Subject: Application for Planning Permission reference M-61-14-PL - The Litten

I refer to the above application for Planning Permission to demolish an existing residential building and garage at "The Litten" and construct three residential properties and new garage.

Ground Floor / Site Plan 1:100

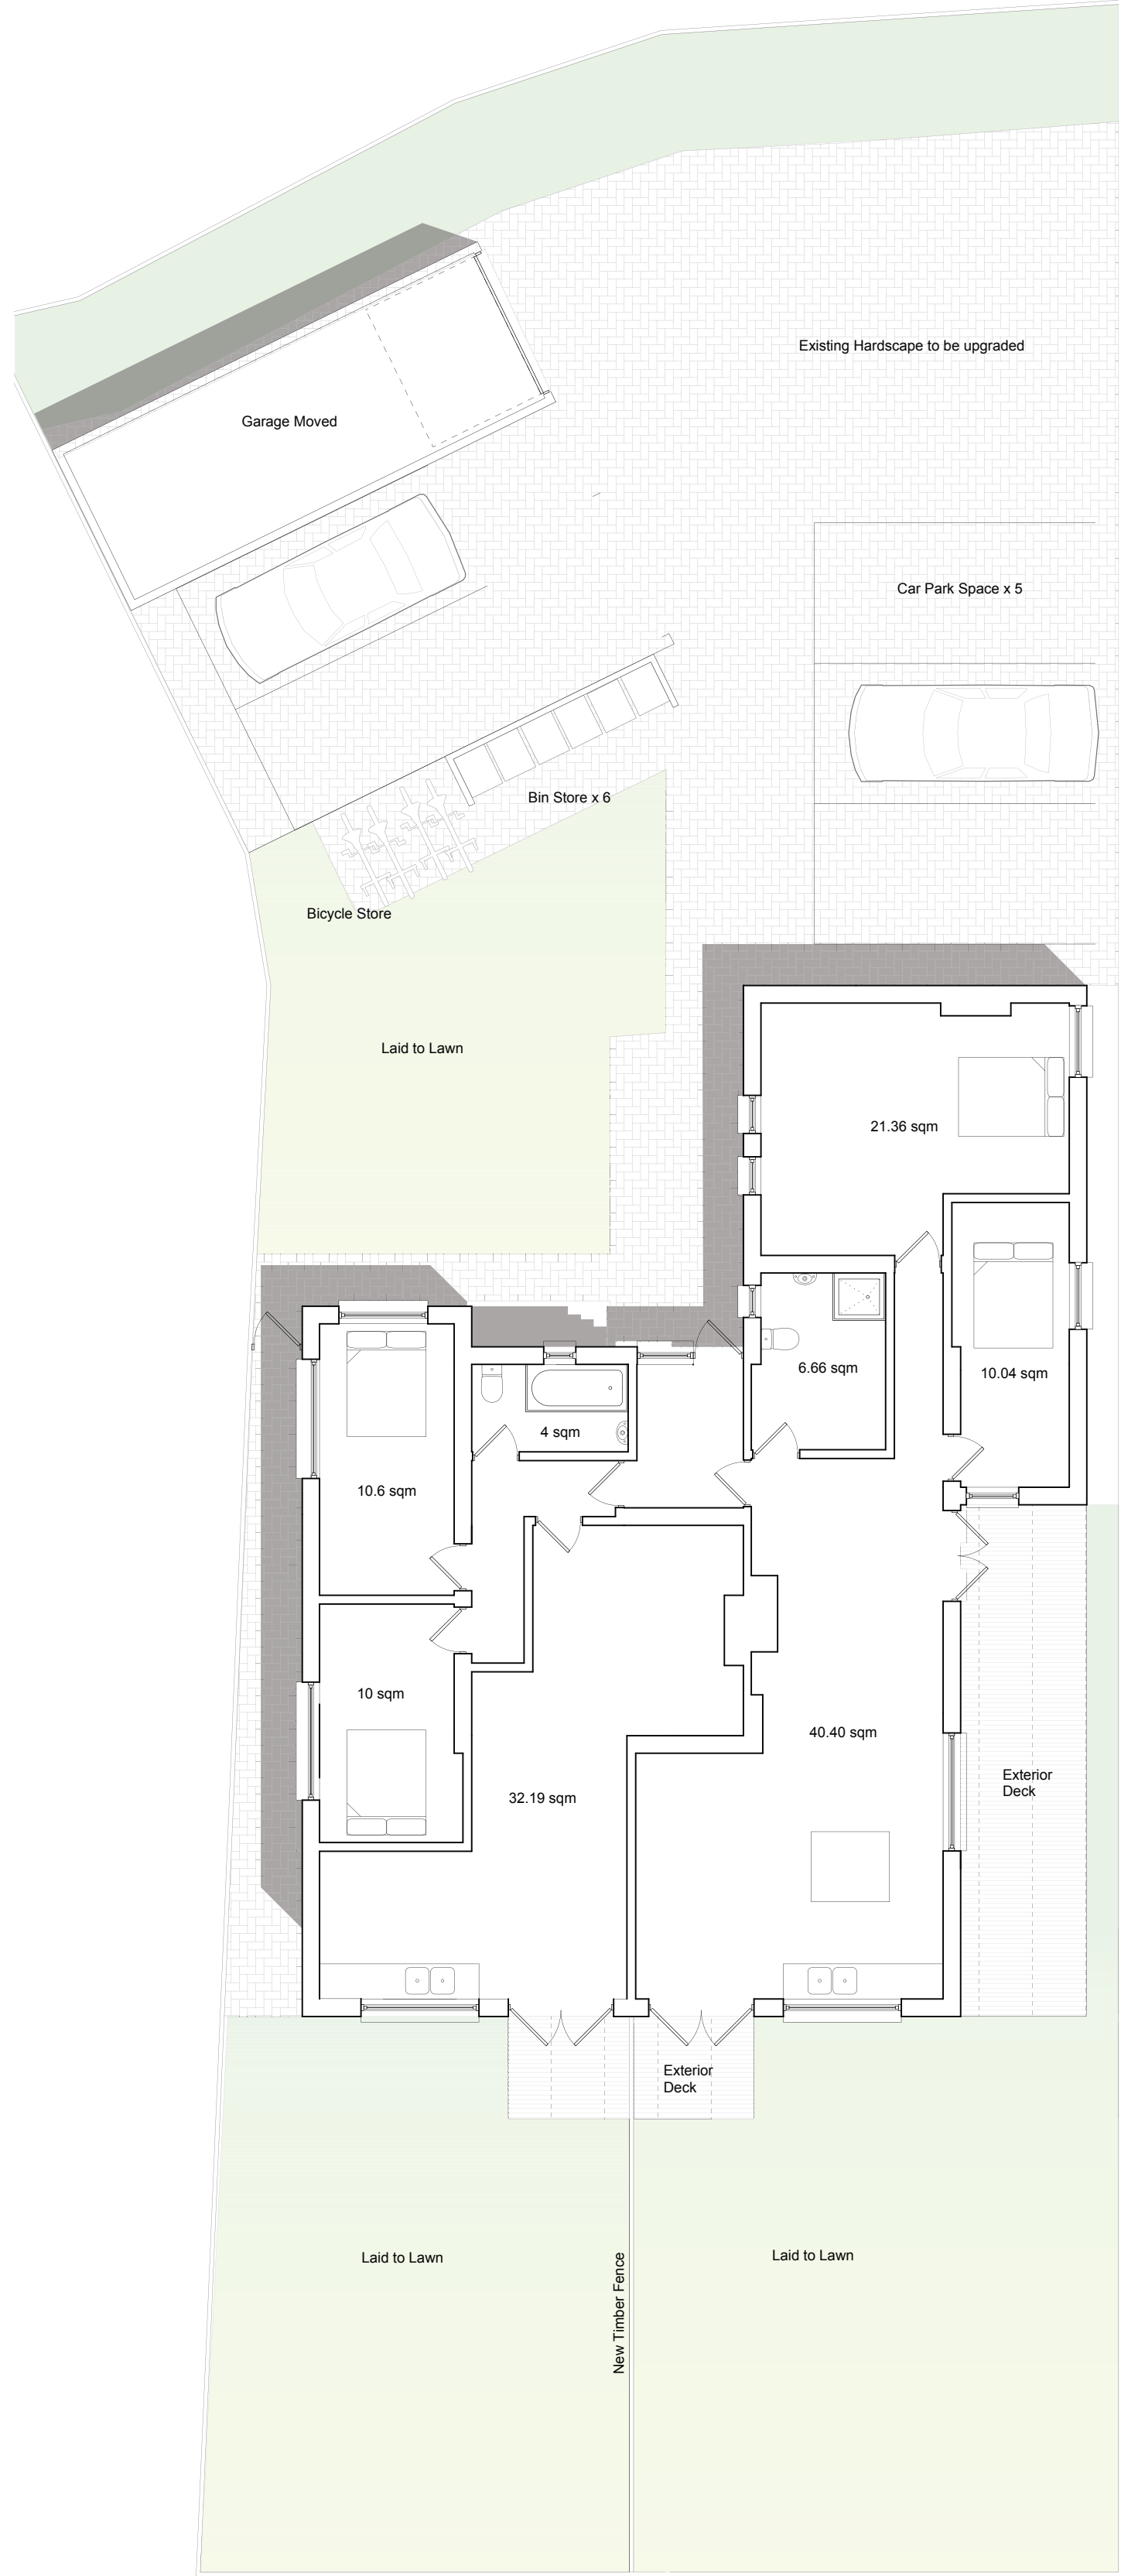
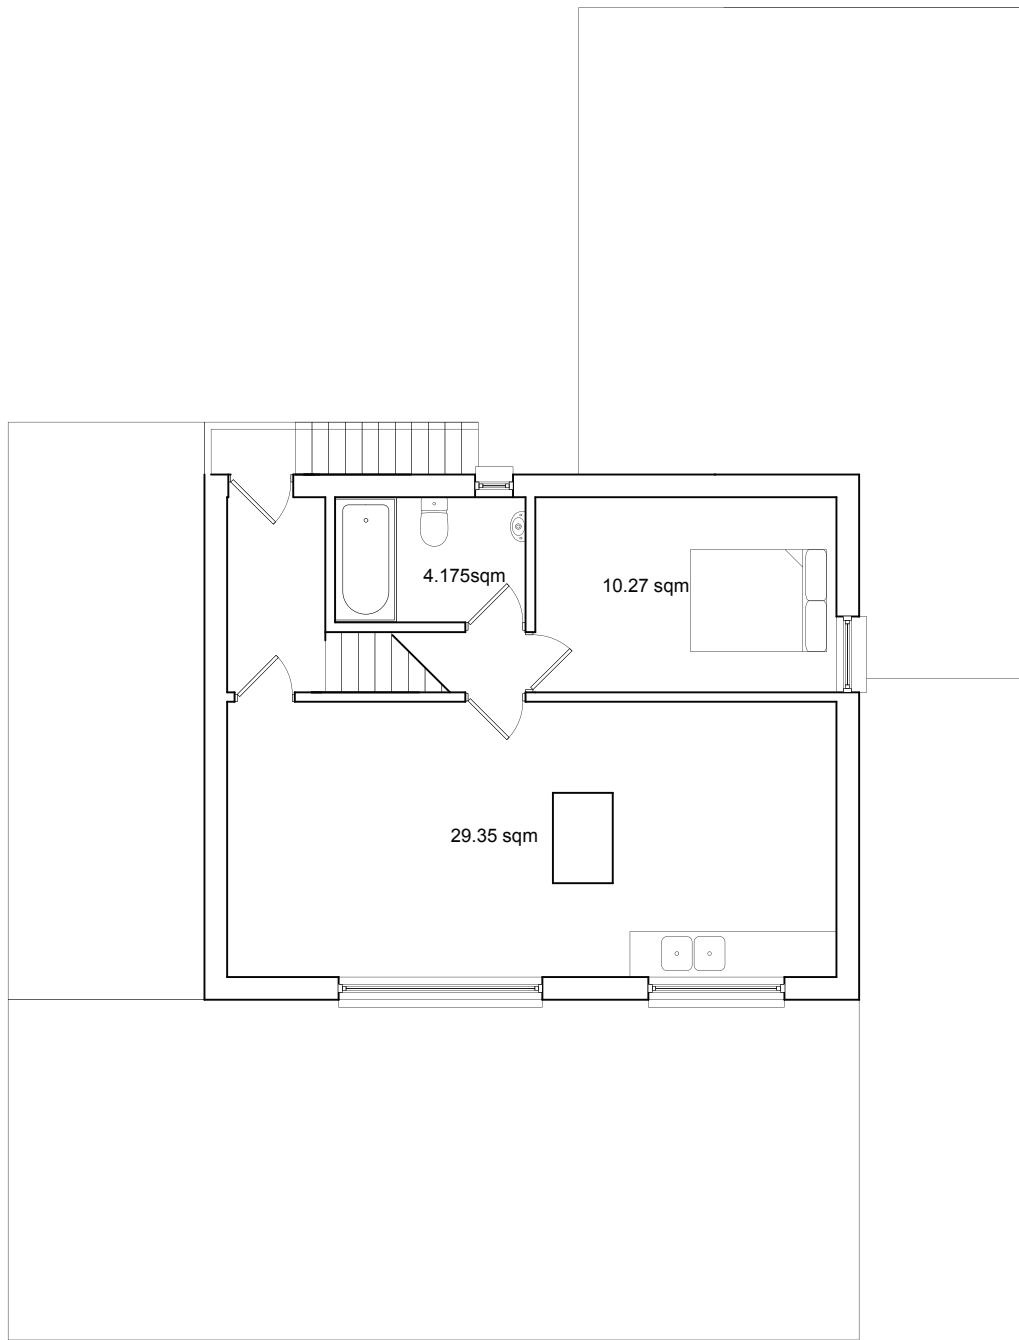
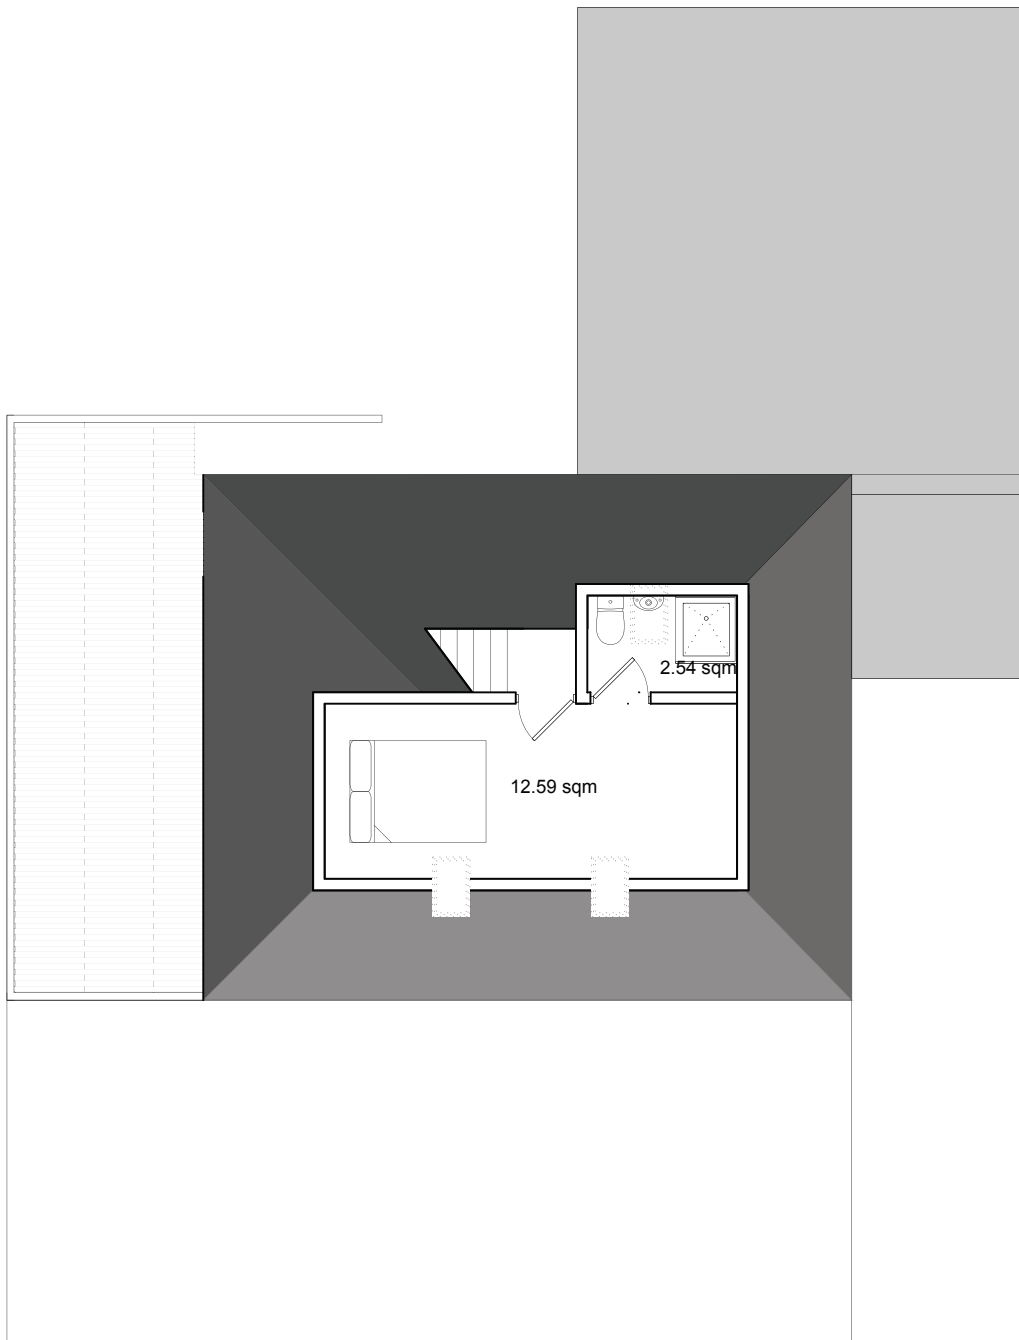
- iv The Site proposed layout plan (Block Plan) implies the Site will only have one double-vehicle access onto Ancton Lodge Lane with all cars having to use this access. However, a close inspection of the proposed site layout reveals that there is insufficient area for cars to manoeuvre into all of the three parking spaces which are located adjacent to Ancton Lodge Lane and alongside the double vehicle access onto Ancton Lodge Lane. Access to the two parking spaces next to the building will be impossible if a vehicle is parked in the third parking space from the building.

- a. To enable access to all three parking spaces alongside Ancton Lodge Lane it will be necessary to pave over more area and relocate the waste bin area. However, this will further increase the hard area and rainfall run-off from the Site.

- b. It may be that the proposal shows only the double vehicle access onto Ancton Lodge Lane. However, because the proposed parking situation is unworkable, there is a high risk that, if planning permission is granted for this proposal, during construction or at a later date lenience will be given to allow altering of frontage such that it becomes a double width vehicle access plus direct access from the lane into three parking spaces. Thus a total open width crossing the verge of five vehicles. Such risk is totally unacceptable.
